City of Portland, Maine - Building or Use Permit Application

Permit No: 01-1503	Issue Date: DEC 19 2001	CBL: 337 C093001
-----------------------	----------------------------	---------------------

Proposed Project Description:
remove 10' x 14' deck and legalize shed
be sure removed

RE: 79 Stuart Street – 337-C-093 – R-3 zone

79 Stuart Street  
Portland  
Maine

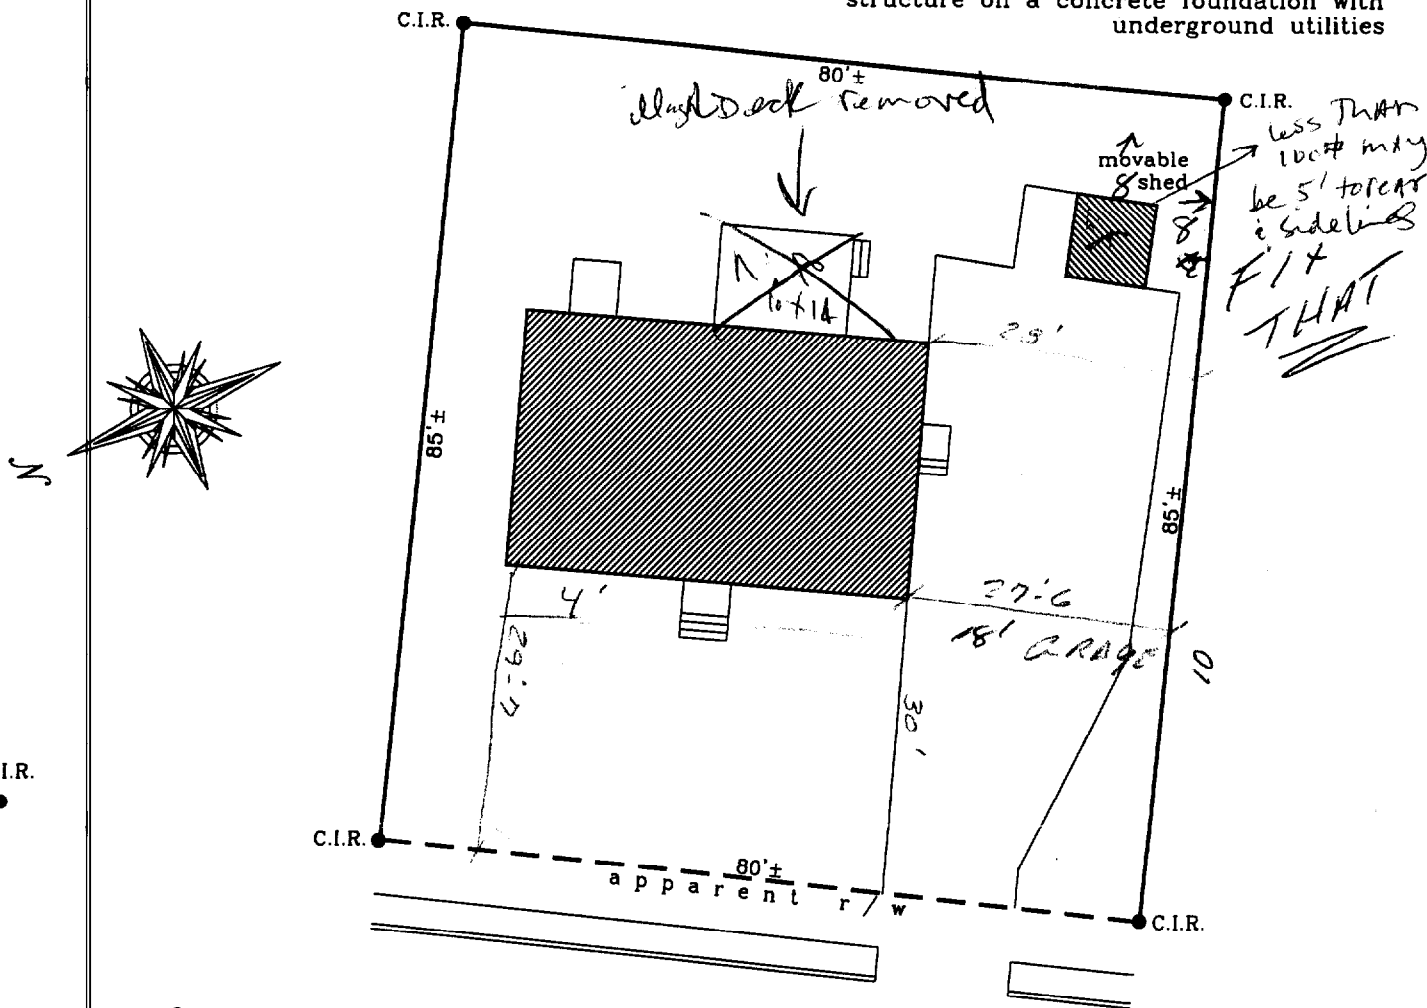
Please note, as I related to you by phone, that my research of our files indicates that there have been no permits for several of the present structures on site. I do not find a permit, or variance to allow the rear 10' x 14' deck. This deck, according to your submitted plot plan, shows only a 19.5 foot rear setback instead of the required 25 foot. This deck shall be made to conform to the current zoning and building codes, by applying for a permit and adjusting its size to meet the required rear setback of 25 feet. It may also be removed to gain compliance.

The rear 8.5' x 8.5' shed also does not appear to have a permit on file. At present, the shed appears to meet the current setbacks for an accessory, detached structure, less than 100 square feet. However, to legalize this shed, it requires a permit and approvals thru this office.

My research did show that the rear bulkhead also extends into the rear setback. However, the Zoning Board of Appeals did grant a variance in 1991 for that rear setback for the bulkhead.

12/12/01
OK To issue permit
GARAGE OK Now
with illegal Deck removed
& legalized The 8.5' x 8.5' Shed

12/10/01 - Deck removed - see permit # 01-1503
